Subject: RE: Springfield, Hook Lane ref AL/112/21/DOC

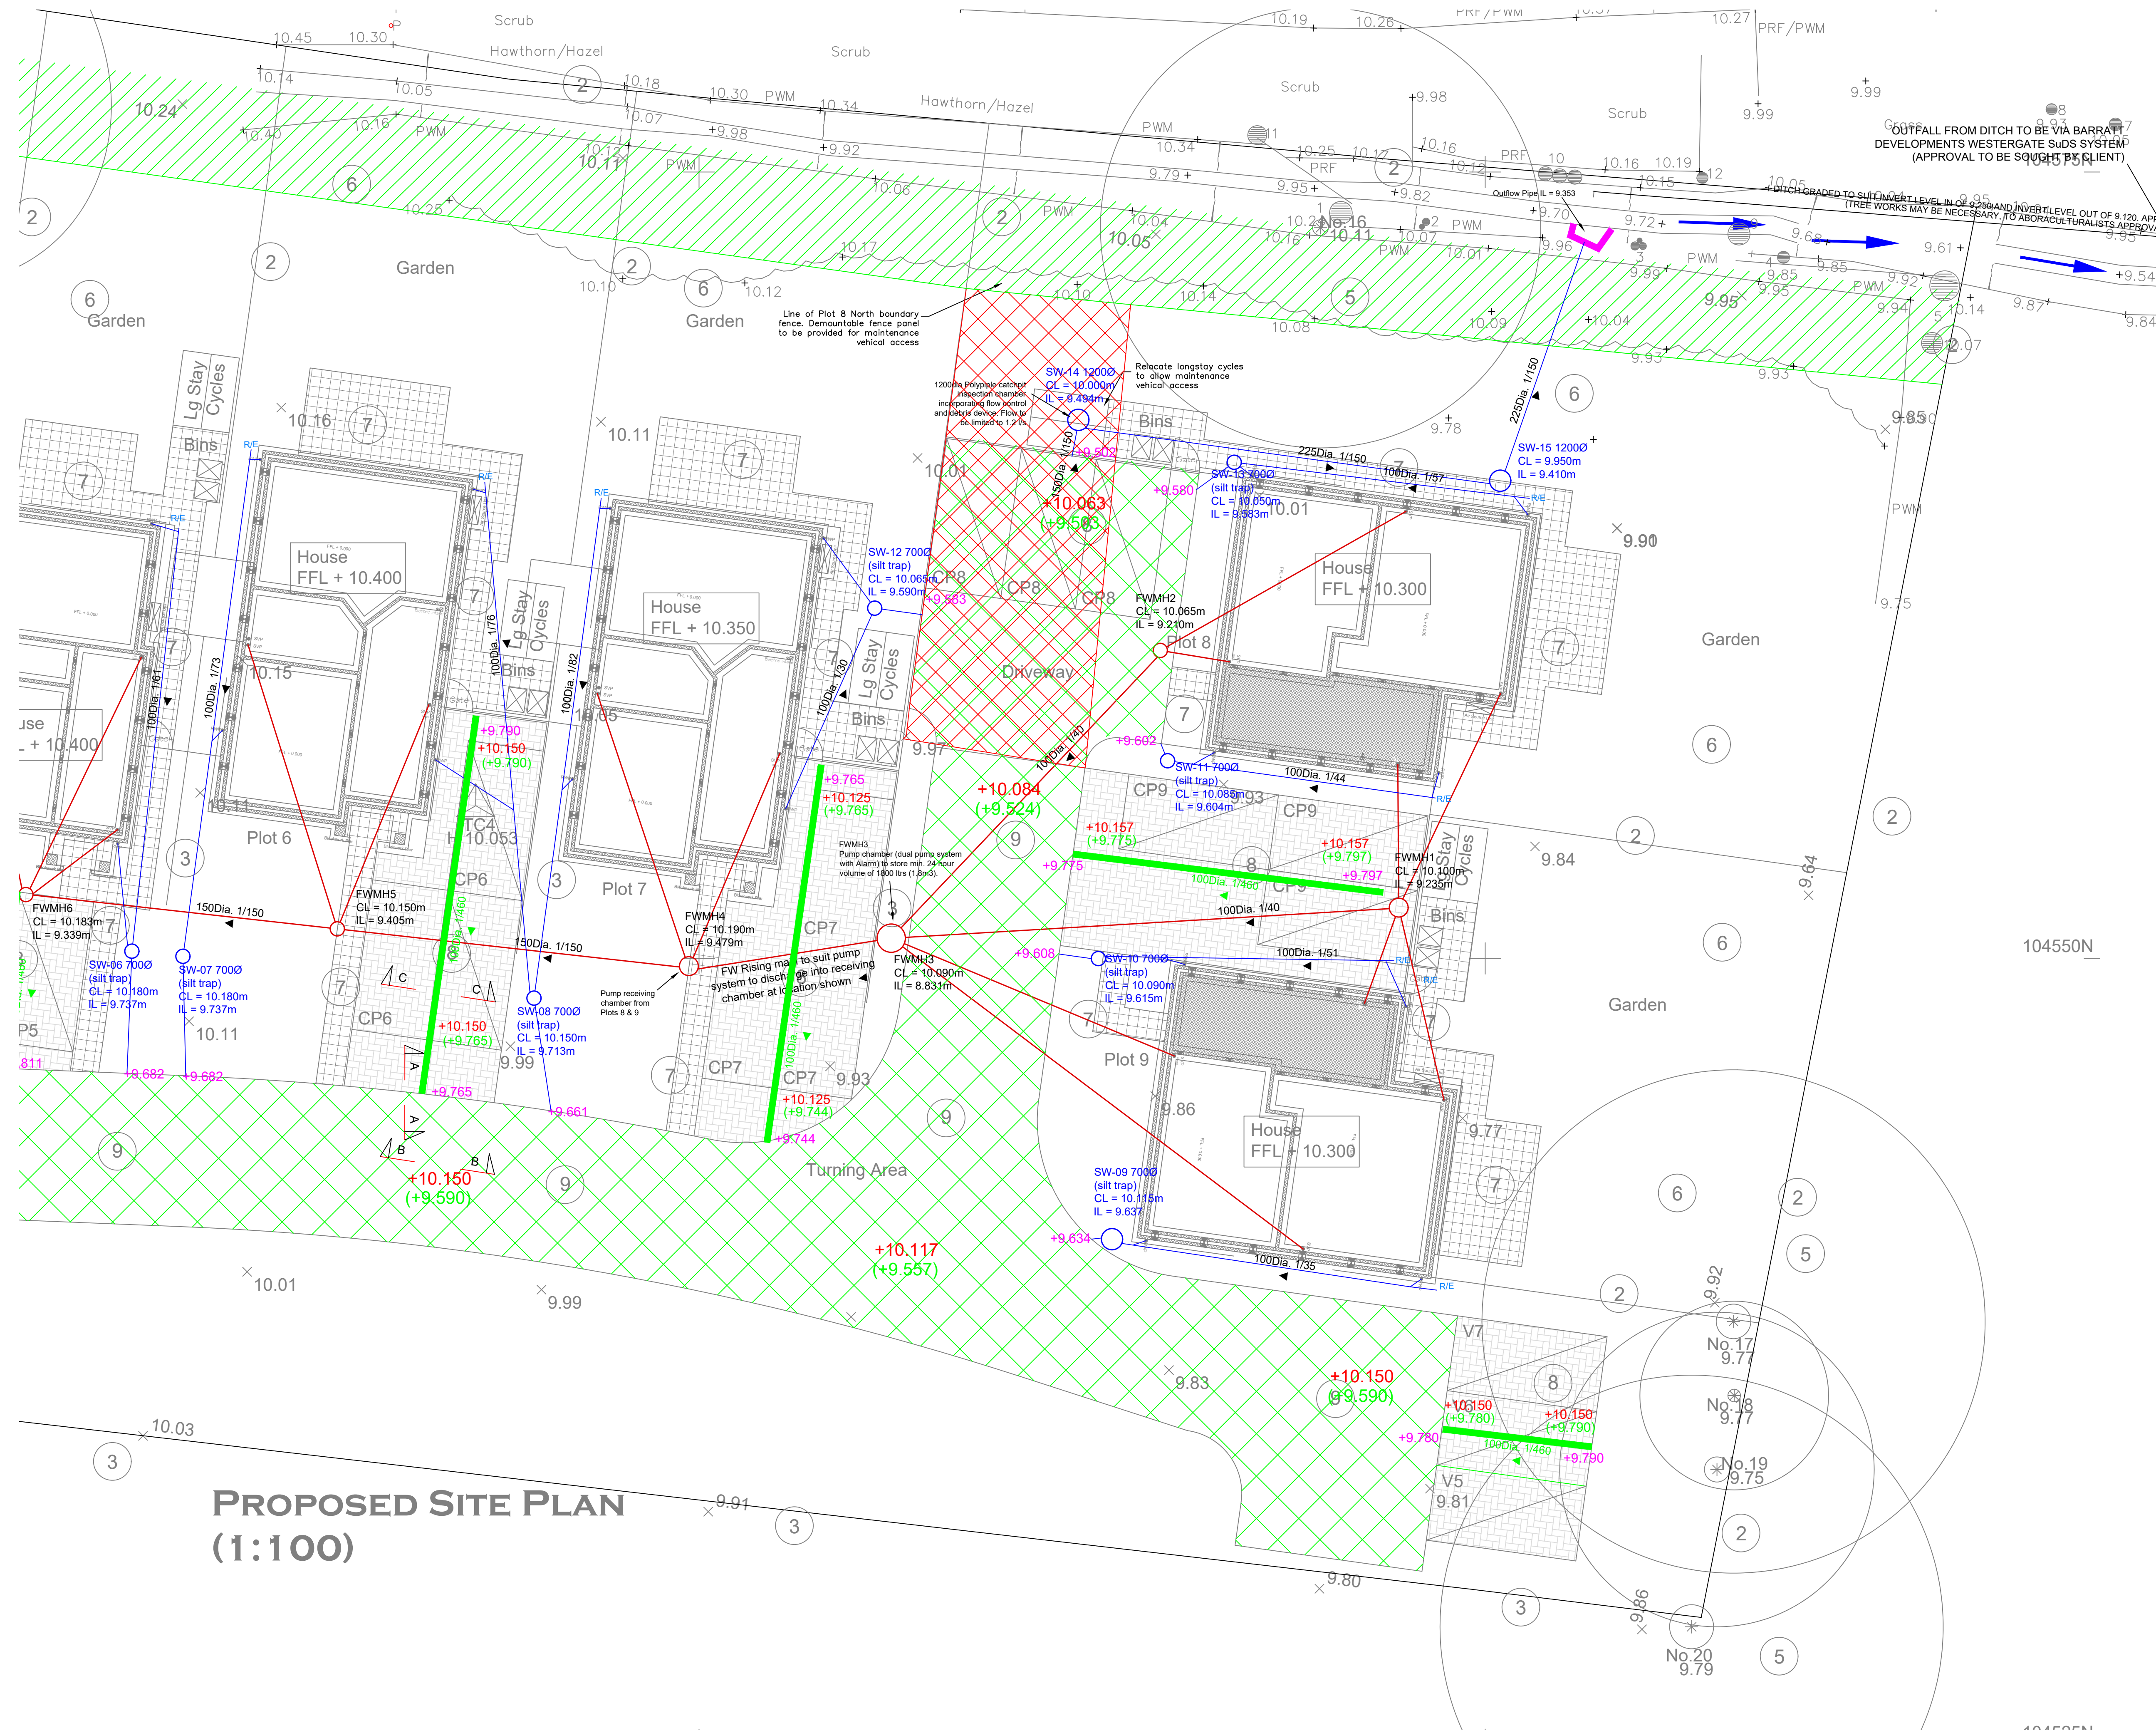
1. Calculations have now been submitted, however these do not include a surcharged outfall as requested previously (point 2 in response of 14th September). A surcharged outfall must be modelled with water level set to the top of bank of watercourse level.
2. Winter groundwater monitoring for the period 30/01/21 to 13/03/21 has been supplied. As have flotation calculations. These show the design to be adequate, even if groundwater rose slightly above that recorded.
3. The unit reference of the hydrobrake must be referenced on both the construction detail drawing and layout. Hydrobrake reference number must be consistent with calculations.
